Proposed First Floor Plan

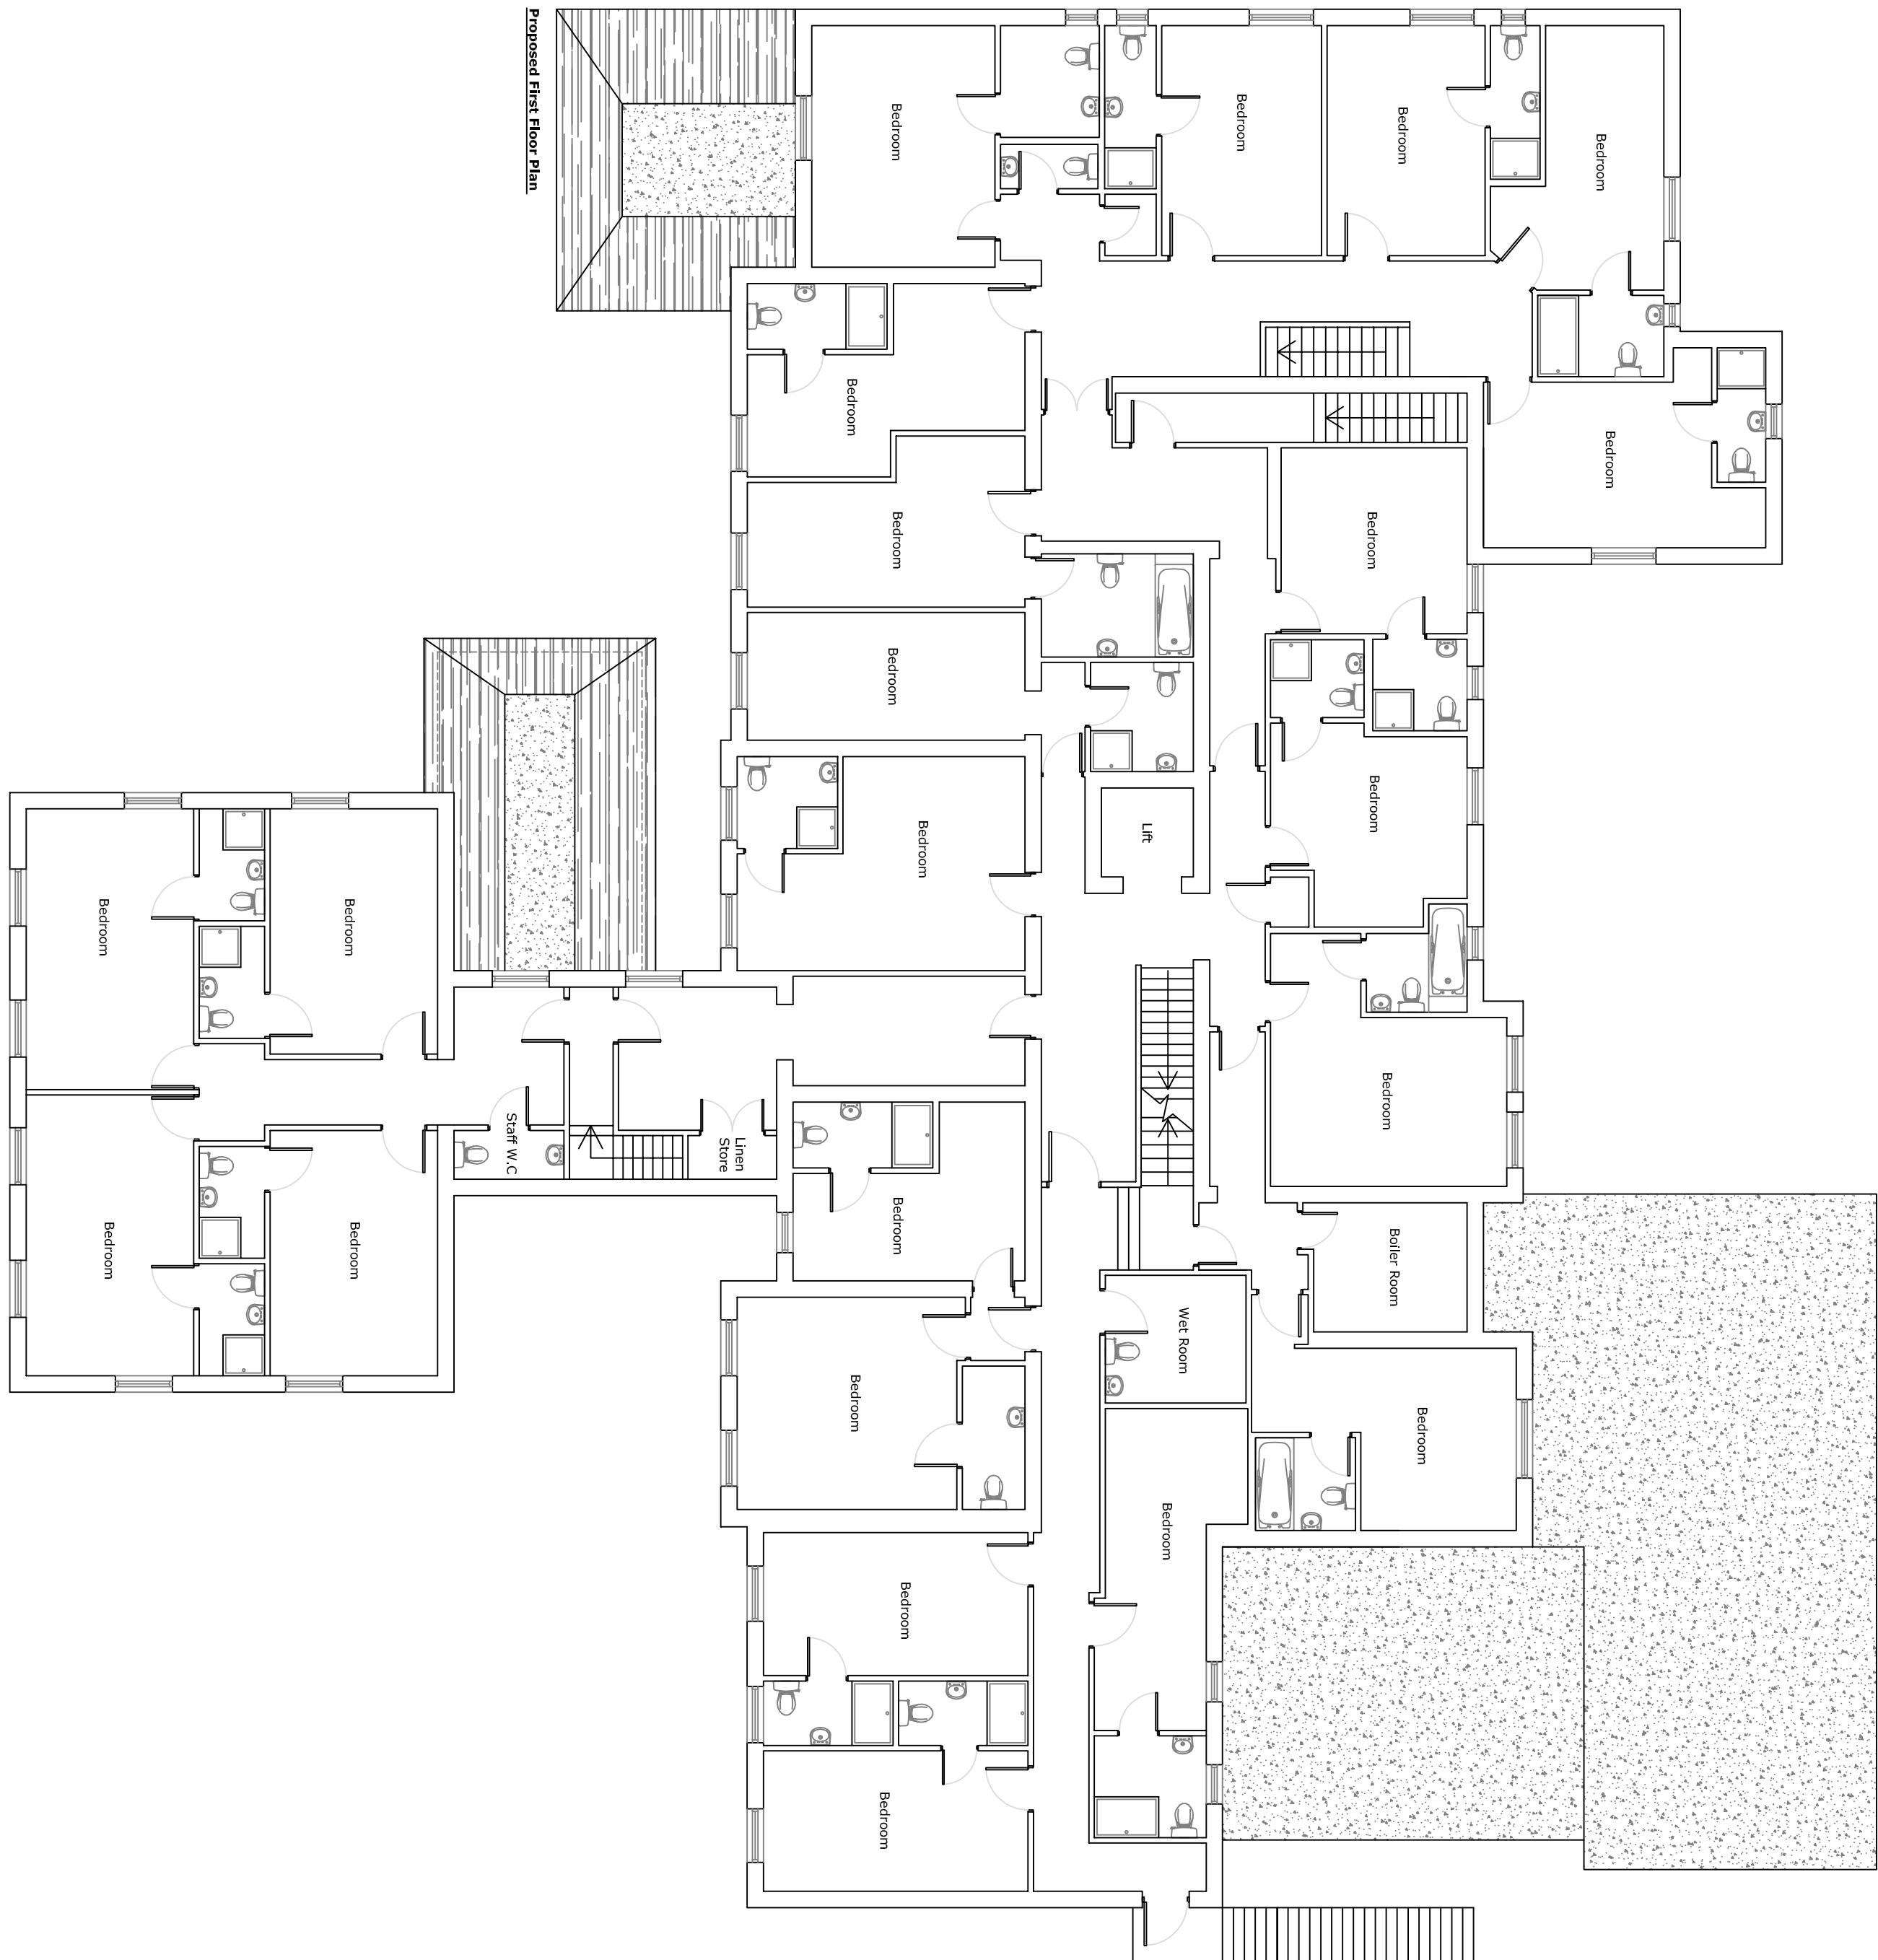
I have been looking at the site history and I believe that this new application is an amalgamation of BR/134/17/PL, BR/314/18/PL & BR/316/18/PL but without the 2 bed FF extension on BR/314/17/PL and with 1 extra bedroom in the new second floor. Thus it will represent a net loss of 1 bed over what has previously been approved. Is this your understanding also? Are there any other changes that I should be aware of? There will also be a loss of a bedroom on the ground floor to provide a new meeting / training room area. This is currently shown as a bedroom between the lounge and laundry room. Jack can change plan and send this over, I wasn't aware we added a bedroom to the top floor? Can you check this?

Proposed Ground Floor Plan

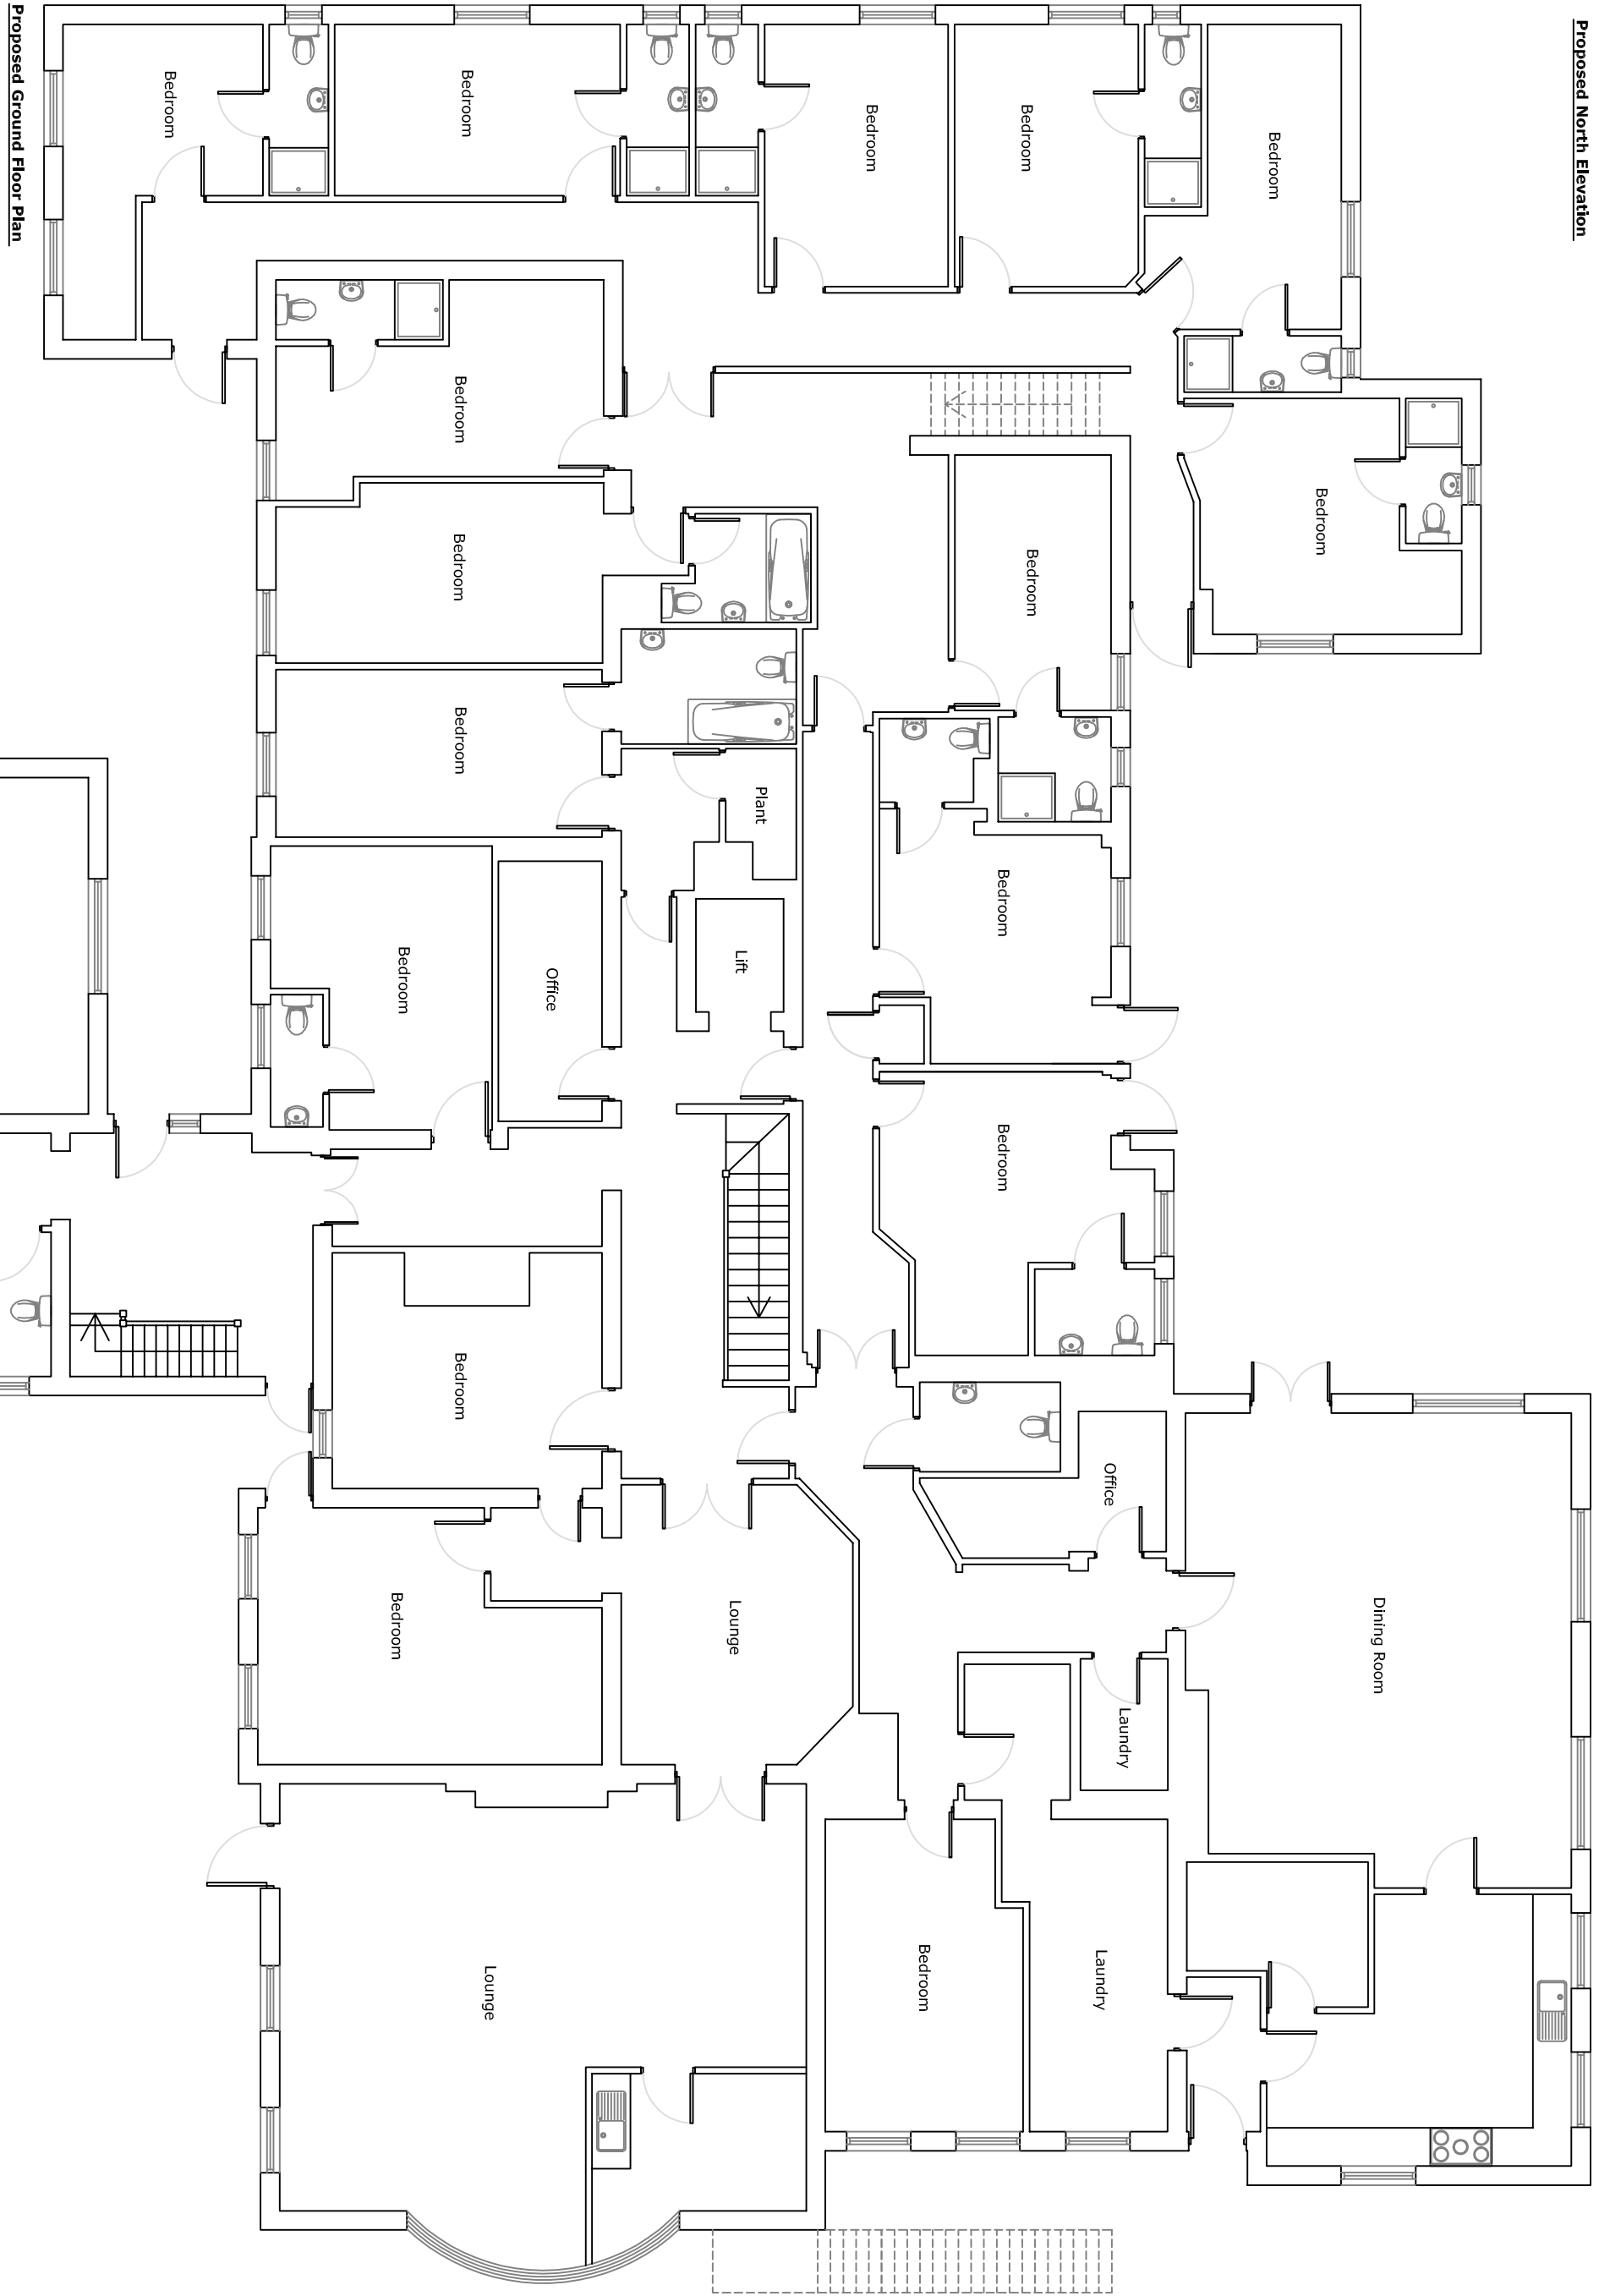
I note that on BR/134/17/PL there were changes shown to the access (widening) and the parking area with a minibus space shown where you now show two the new parking spaces. Also changes to the fence line & bin store. Can you advise why these changes are no longer required. I note that these changes were welcomed by Highways at the time. Our plans are to upgrade the minibub in the near future and begin parking this at one of our other sites in the area in order to better use the existing hardstanding car parking space. We had hoped this would avoid the need to loose further garden space at this site and protect the loss of trees. We are however happy to reconfigure the layout as per the revised parking layout to provide a solution more akin to what was previously welcomed, but not requested, by highways. Jack can you please send me a copy of this revised plan?

I do not want to formally accept the revised parking plan until there is clarification on the above matters.
